LSC Responses to EPC TIS Redline Comments

1 Grandview Reserve Filing No. 1 Transportation Memorandum

(LSC #S244090)
March 21, 2024

Figure 6b
 Long-Term Directional Distribution
 of Site-Generated Traffic

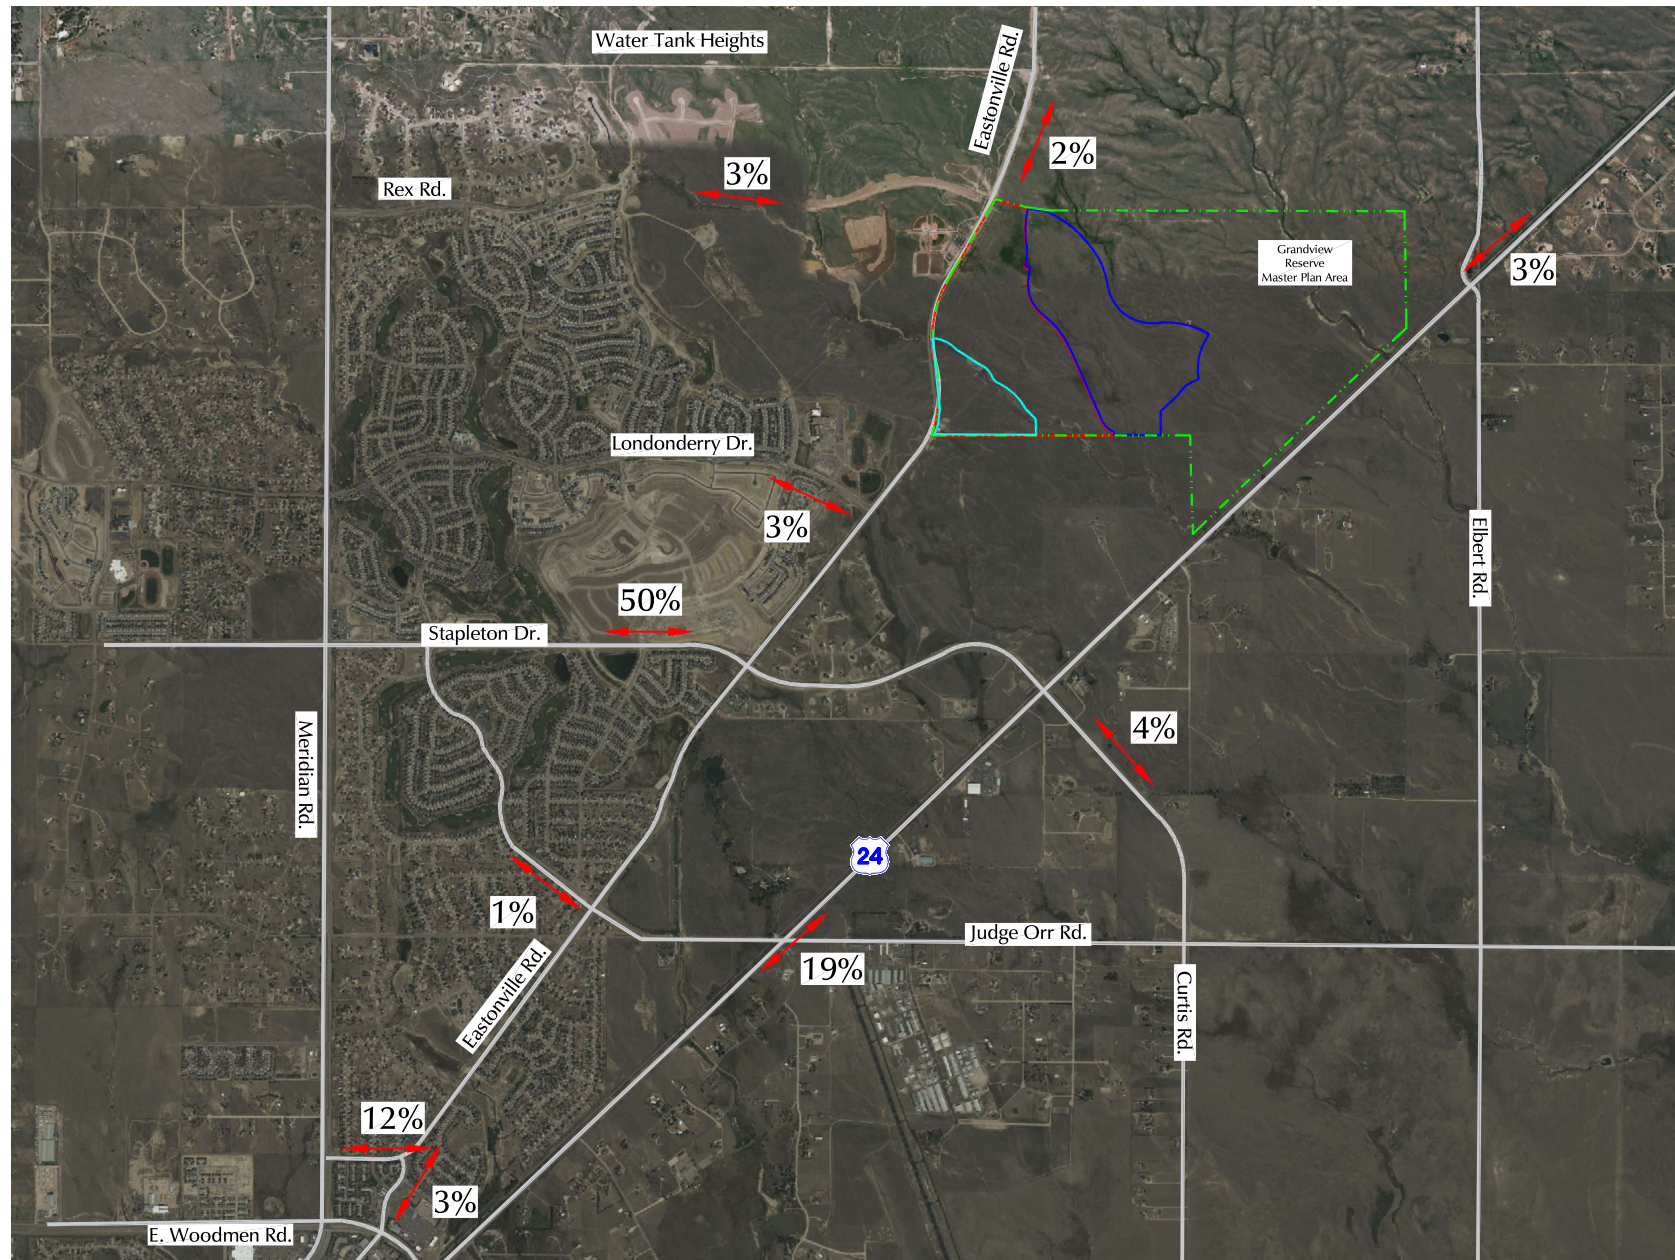
[Include long term traffic](#)

Author: kdfer Subject: Sticky Note Date: 5/28/2024 4:14:36 PM
LSC Response: Revised as requested.
